AW-71-18-HH – CHECAA Objection – 25-5-2018

Head of Planning Services
Arun District Council
Maltravers Road
Littlehampton,
BN17 5LF
25 May 2018

**FURTHER MATTERS OF OBJECTION – AW/71/18/HH, 'Queenslawn',
36 Kingsway – within the Craigweil House Area of Special Character and the
Craigweil House Conservation Area.**

Tree survey

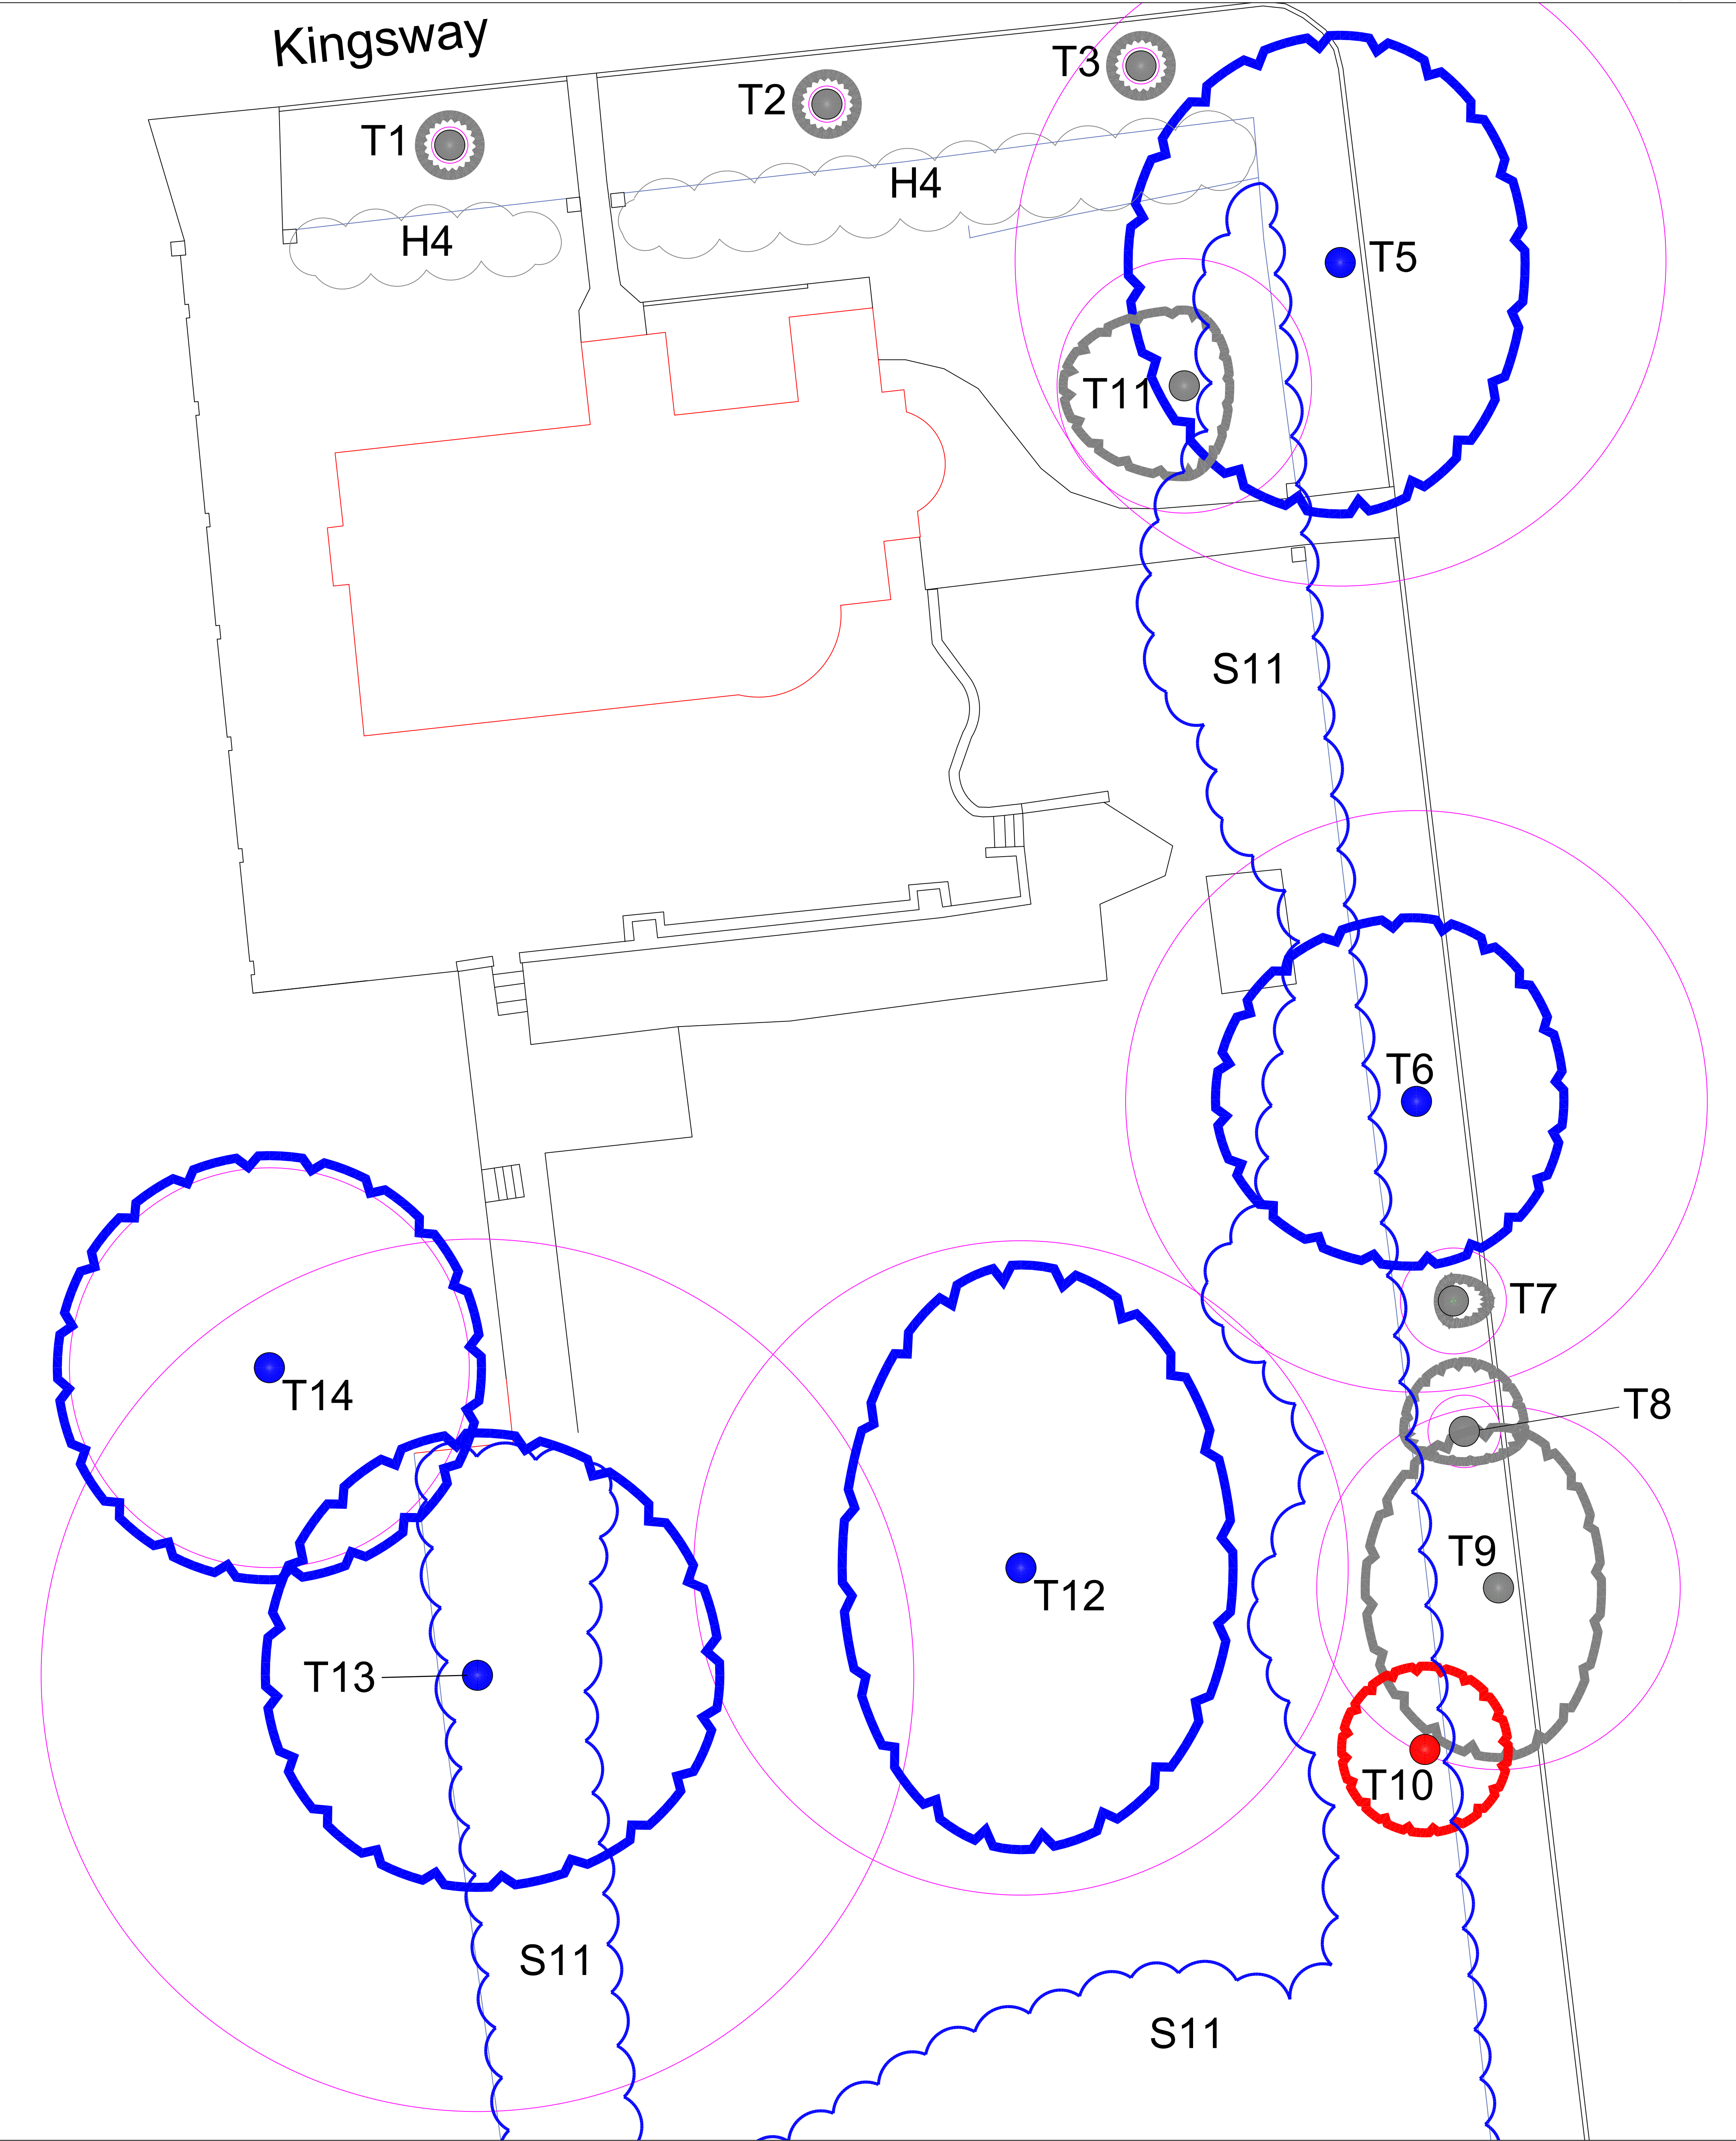
It is noted that the applicant gives no RPA measurements, while producing irrelevant figures claimed to be the extent of the canopy spread of no significance in this case.

However, the RPA for this Horse Chestnut Tree (marked by them as 'T5') is inscribed in a circle and that circle embraces the whole of the concrete road in Queensway, and part of the junction which is Kingsway. It is then shown as spreading across the eastern verge of the house opposite on the eastern side of Queensway – 'Kingslawn', 38 Kingsway' – and CHECAA says that this is absolutely ludicrous. Patently, the feeder root system, in this case, cannot be in a true circle – in stops at the verge, and the trunk is hard up to the kerb and concrete road of Queensway as is seen in the attached photographs. So that RPA is totally spurious.

In such circumstances, where the root system is stopped by obstructions such as roads, the Root Protection Area cannot be calculated as a true circle (BS 5837:2012, Paragraphs 4.6.2 and 4.6.3 explains this simply and clearly) where other factors (the roads) indicate that rooting has occurred asymmetrically and, then, a polygon of equivalent area to the circle should be produced. The applicant has failed to do this.

The applicant must understand that the land within the proscribed RPA's is declared sacrosanct for that is where the tree has its feeder root spread, within the top 600mm (2') of the soil and this is where the roots collect their food, water and oxygen. The inscribed circular RPA, around T5, implies that food, water and oxygen is collected through the concrete road and this is not the case and is silly and no true Arboriculturalist would claim that this was a realistic scenario, as does the applicant. It is nonsense for the tree was planted after the concrete road was laid and roots will have taken the shortest and easiest route to find nutrition and that will not have been under concrete.

The fact is that this tree can feed ONLY in the soil of the grass verge next to Queenslawn and the verge to the north in Kingsway, outside the development site area, but that is far from sufficient to sustain such a magnificent tree and the reality is that the root run, which stops at the concrete roads, will have run west into Queenslawn's garden and, therefore, the root spread has now to be seen NOT as being in a circle but in a POLYGON shape of 3 to 8 sides, as the attached illustrations, and we think that a 6 sides Polygon will undoubtedly be the RPA.

Drawing
Arboricultural Impact Assessment,
Arboricultural Method Statement

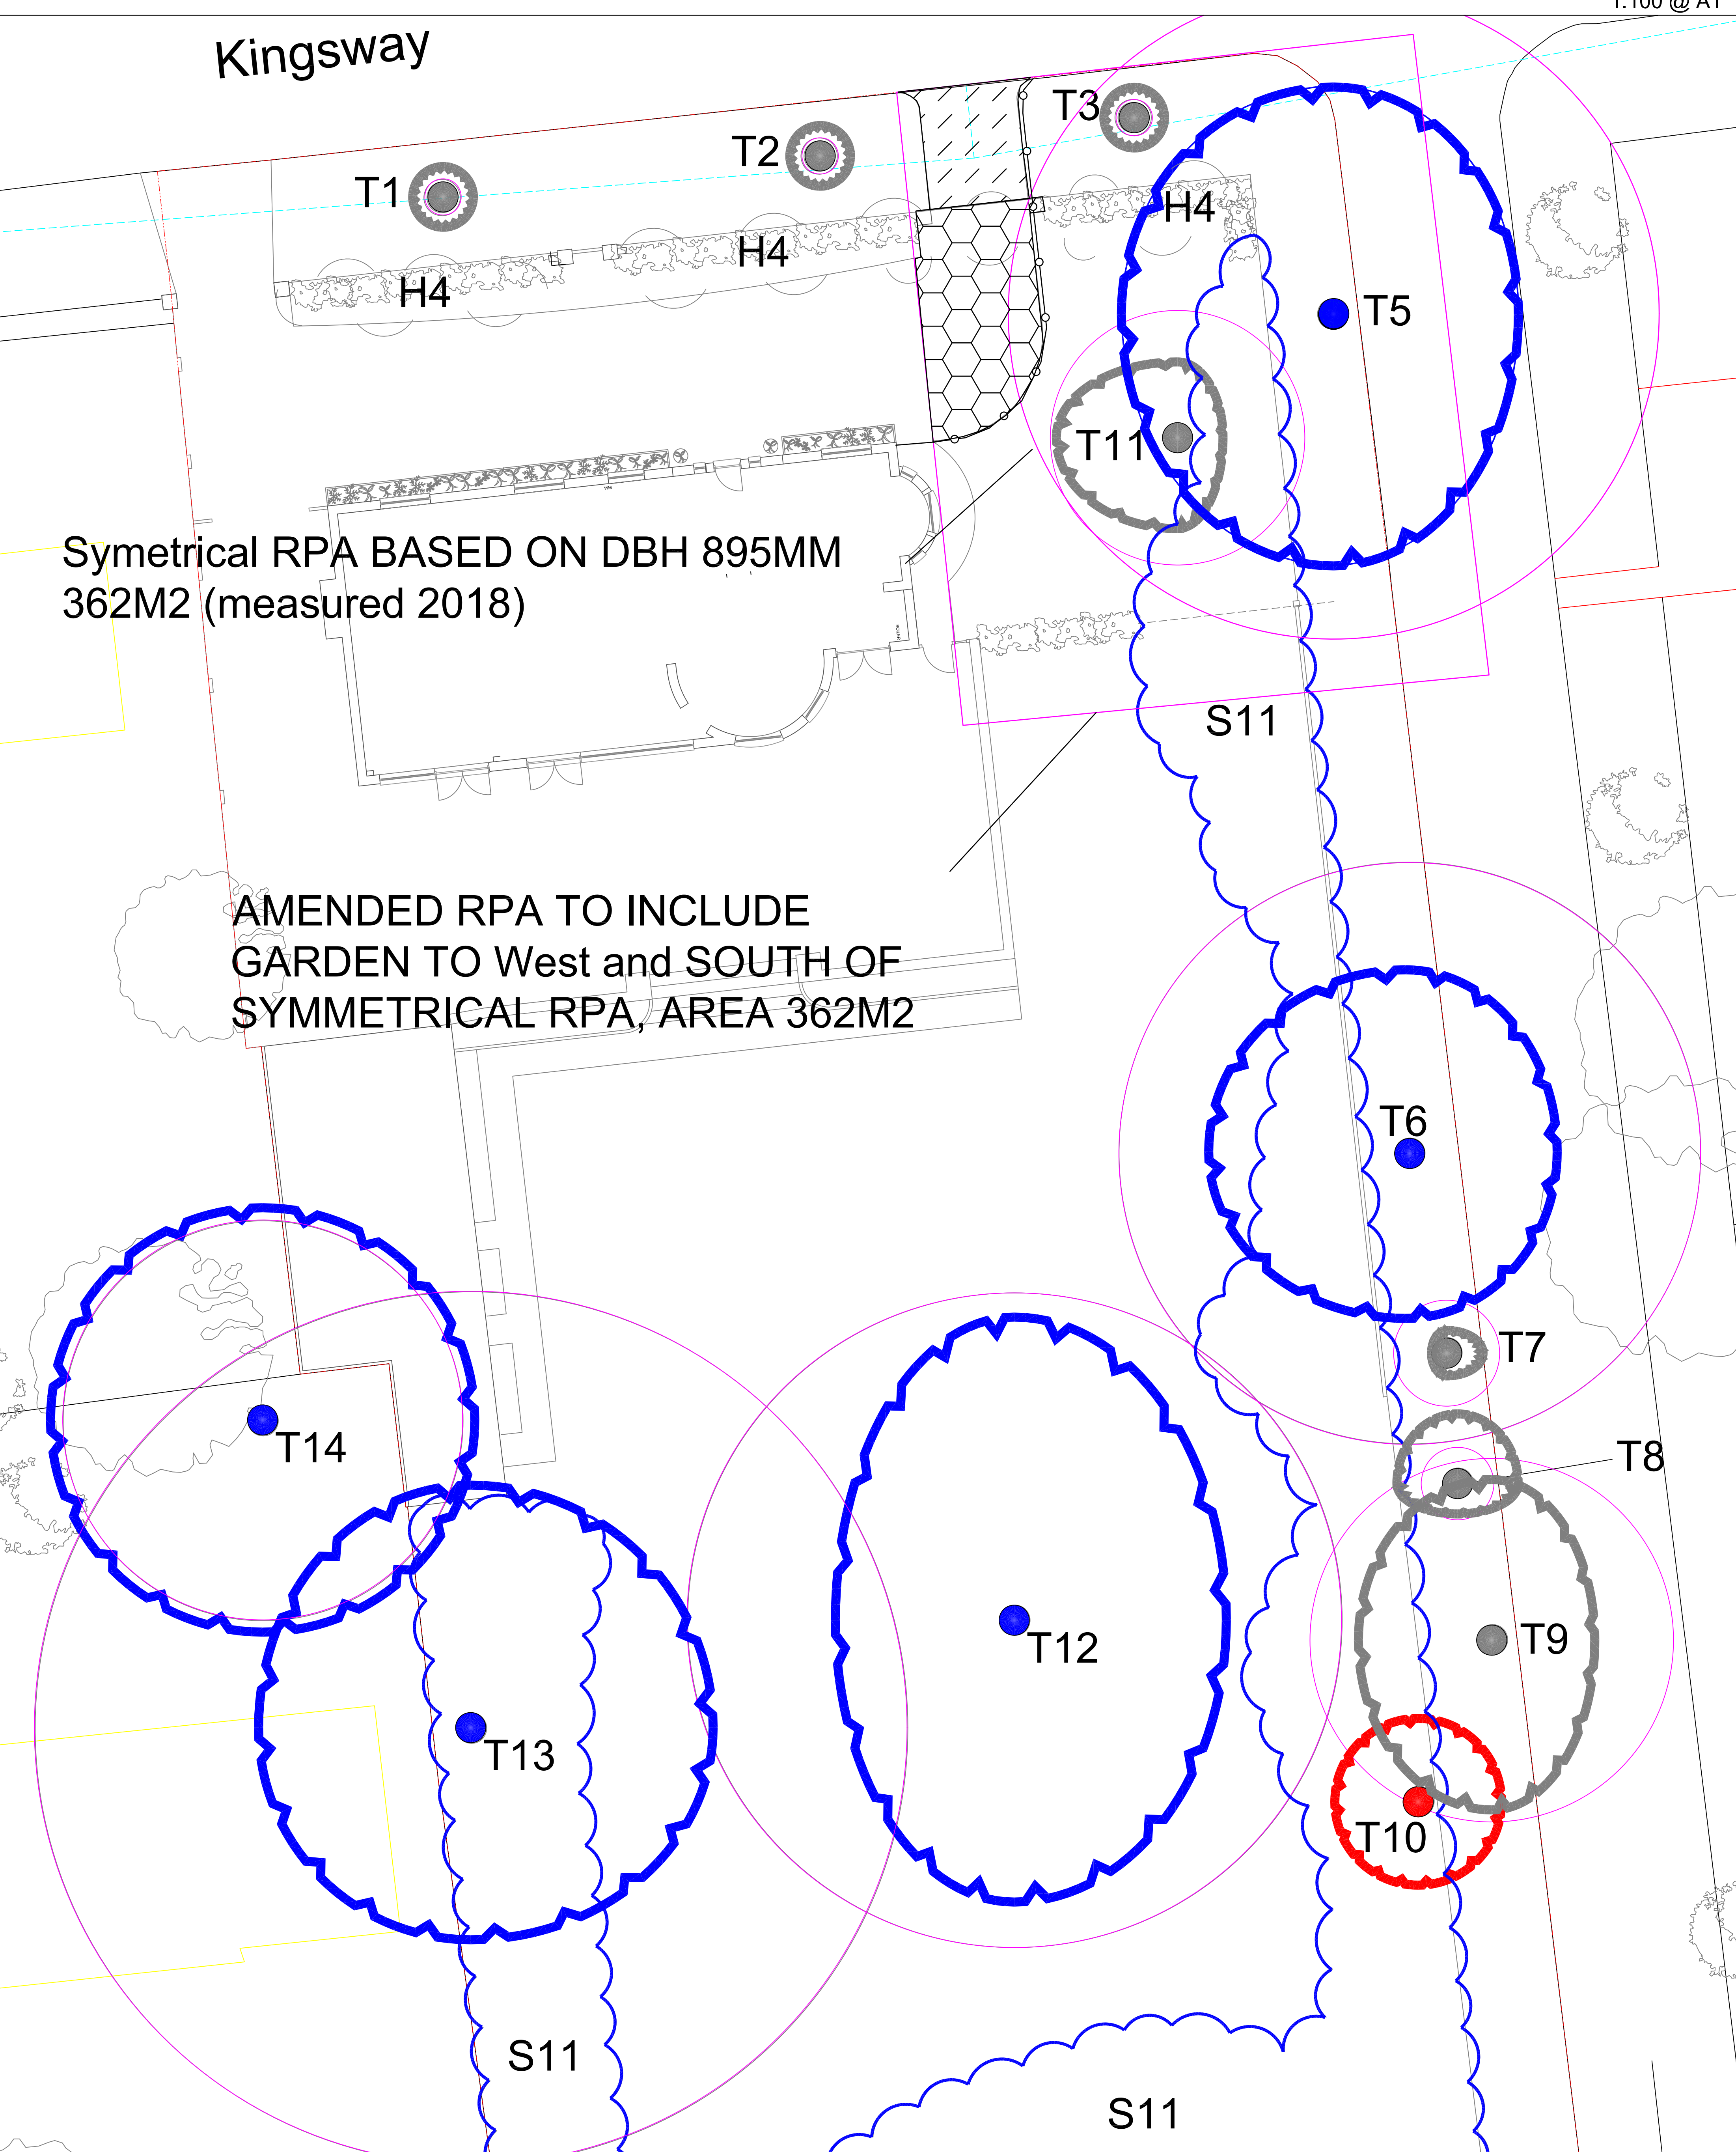
And all the root congestion under that southern verge of Kingsway MUST exclude any consideration of allowing a 4M width to be excavated for the proposed new access, then filled with toxic concrete which will spread and kill all roots present.

Clearly, the roots spread to the front, including the Kingsway verge and the proposed new access, the side and possibly the rear of the house, but that is a matter for Arun District Council's Tree Officer to consider and determine on site and we ask that he, please, be asked to pay extremely close attention to the issues outlined above. According to the applicant, the RPA ENDS at the precise point where it is desired to excavate and create a driveway and that concept defies reason – particularly with excavation and the placing of toxic cement involved.
